To: South Holland District Council Application Ref: H02-0598-25

Proposal: **Proposed residential development comprising 3 detached dwellings**

Location: **Land South of Barn Lodge, Commercial Premises, Hereward Way, Crowland**

Date: 23 July 2025

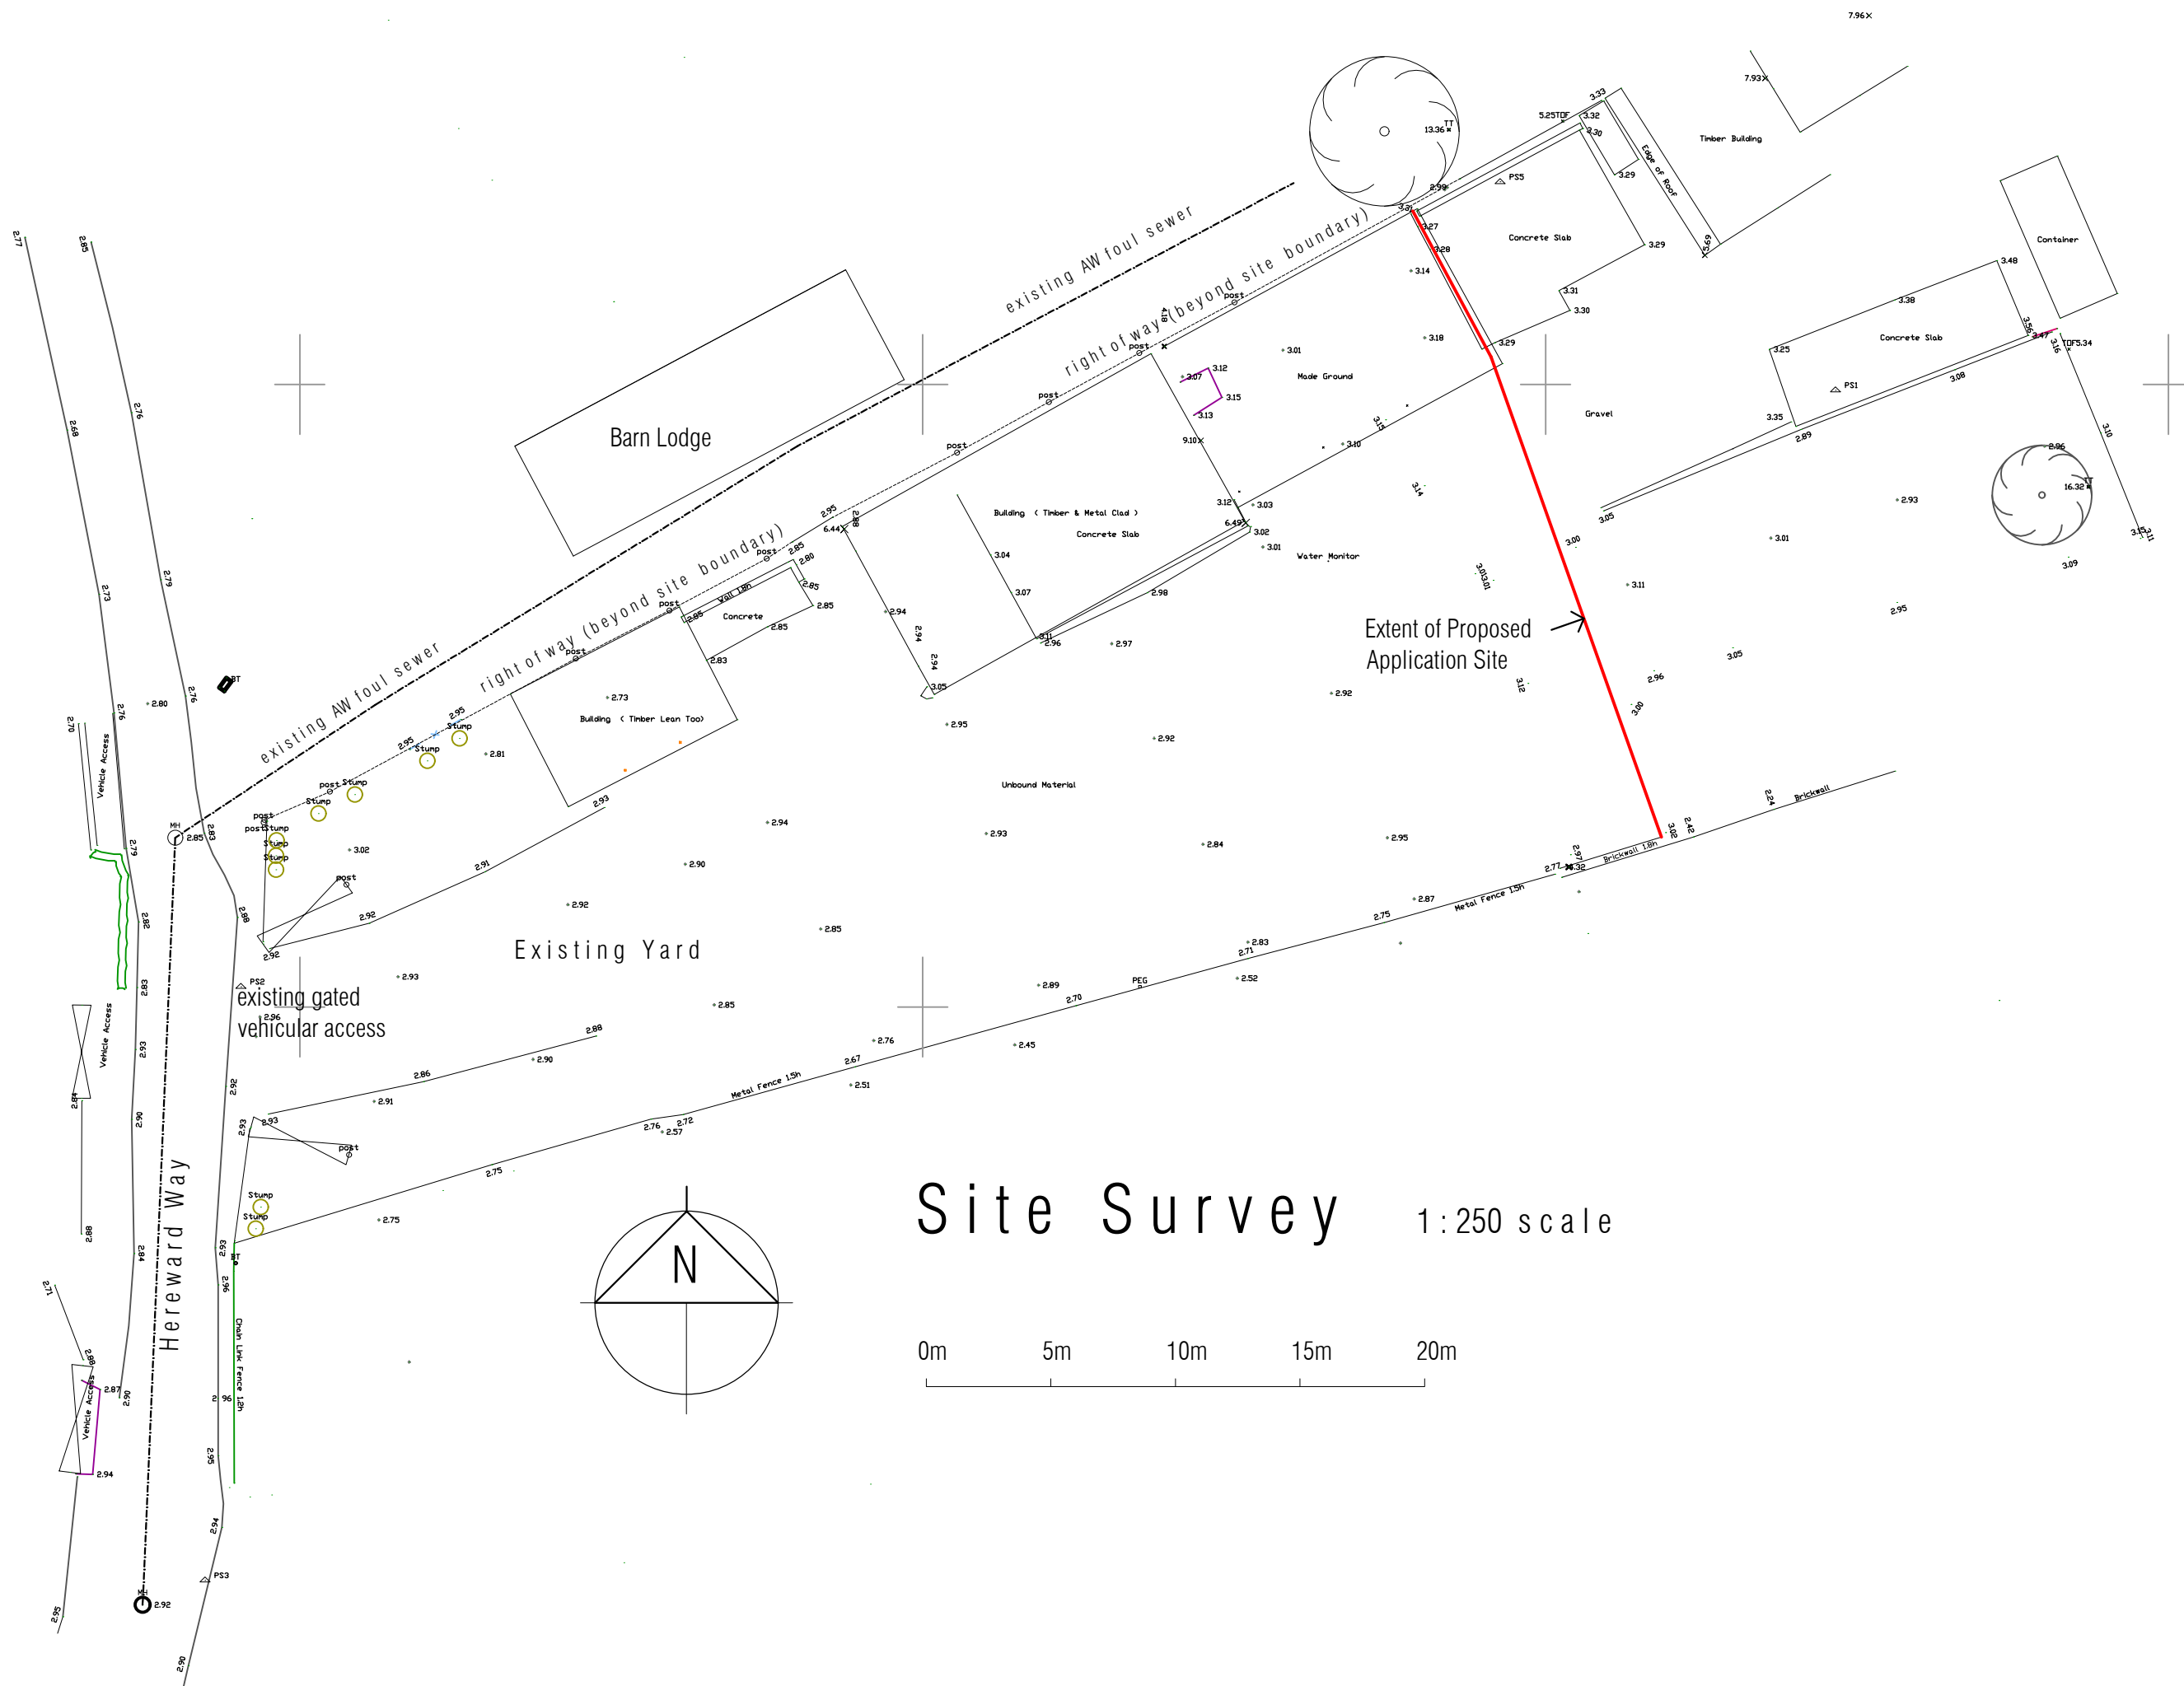
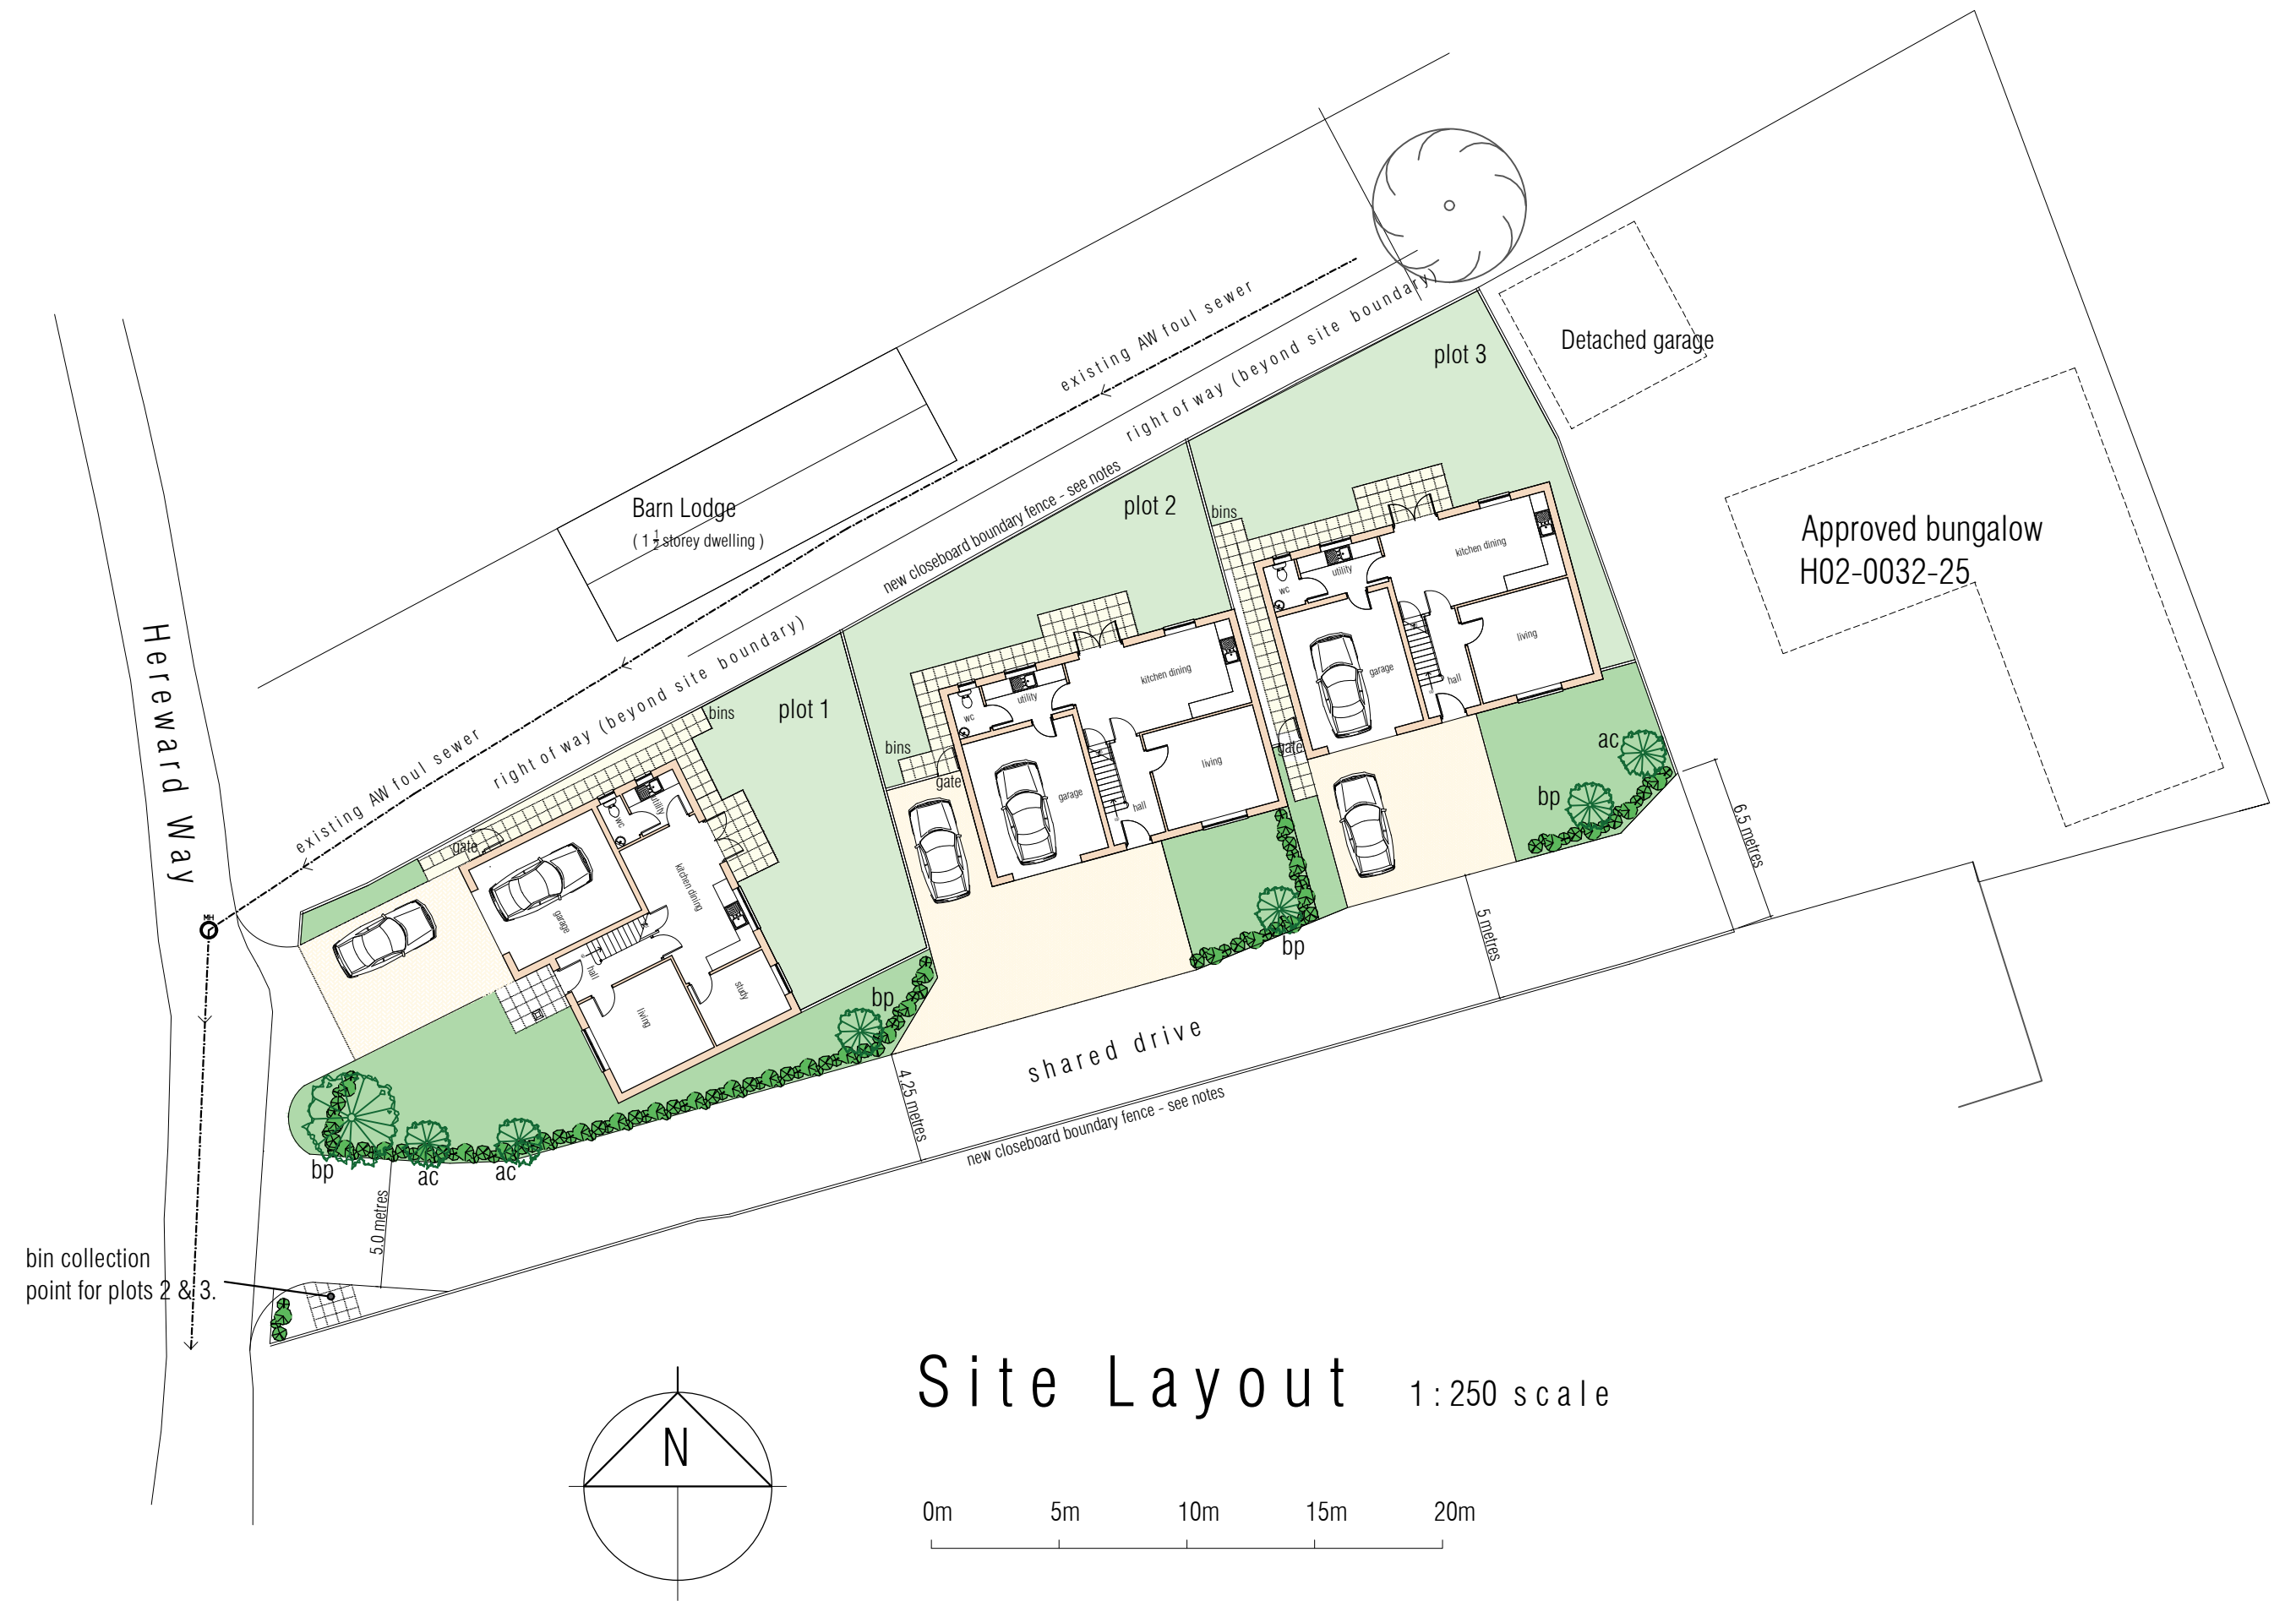
For a garage to be classed as a parking space it should measure 3m x 6m. A four-bed dwelling should have three parking spaces.
